May 6, 2025

REQUEST

Current Zoning: N1-A ANDO (Neighborhood 1-A, Airport Noise Disclosure Overlay)

Proposed Zoning: ML-2(CD) ANDO (Manufacturing & Logistics-2, Conditional, Airport Noise Disclosure Overlay)

RZ-1  
RZP-2024-064

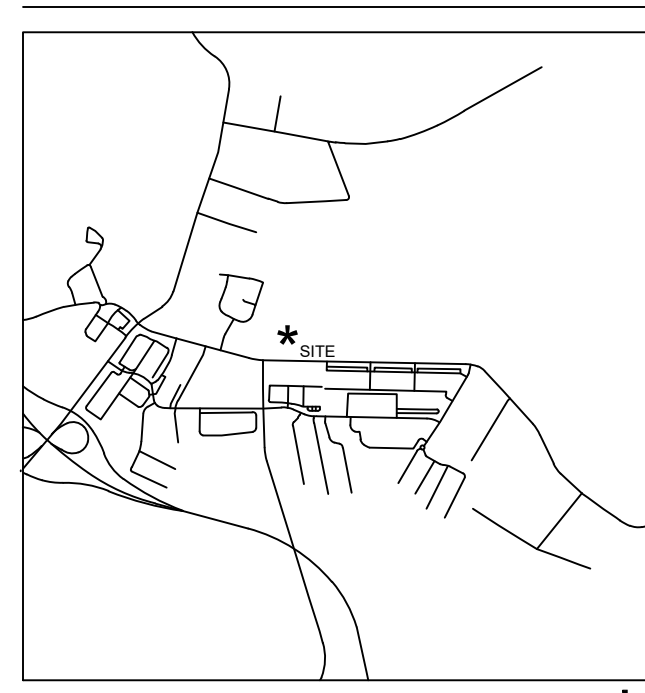
1. ~~Reduce the maximum height to 40' to match adjacent I-2(CD) parcels to the east of the site.~~ **ADDRESSED**
2. ~~Eliminate N1-A(CD) ANDO from the requested zoning. The entire site and all development standards associated with the proposed use should be under ML-2(CD) ANDO.~~ **ADDRESSED**
3. ~~Extend the 65' Class A landscape yard to all areas adjacent to N1-A and CG zoning. Show the landscape yard across the septic field. A variance will be required following the rezoning process.~~ **ADDRESSED**
4. ~~Revise the proposed use to limit only to contractor office with outdoor storage. Any other proposed use would require a subsequent rezoning.~~ **ADDRESSED**
5. ~~Clearly illustrate the proposed outdoor storage yard area on the site plan.~~ **ADDRESSED**

7. ~~Remove note 8.B referencing proposed PCSO treatment areas.~~ **ADDRESSED**
8. ~~City of Charlotte GIS data indicates a 30 ft PCSO buffer across the site. Please show and label Potential 30 ft PCSO Buffer on the site plan. Any increase of impervious area within such buffers may not be allowed and is not approved with the rezoning process. Stream Delineation Reports are subject to review and approval by Charlotte Storm Water Services. Please include the following note under Environmental Features: "Development within any SWIM/PCSO Buffer shall be coordinated with and subject to approval by Charlotte Mecklenburg Storm Water Services and mitigated if required by City ordinance."~~ **ADDRESSED**

9. ~~Provide a tree survey identifying all city trees 8" DBH or greater and all planted city trees, all existing heritage trees, and any existing areas of the site used for credit toward meeting previously approved tree save or green area requirements.~~ **ADDRESSED**
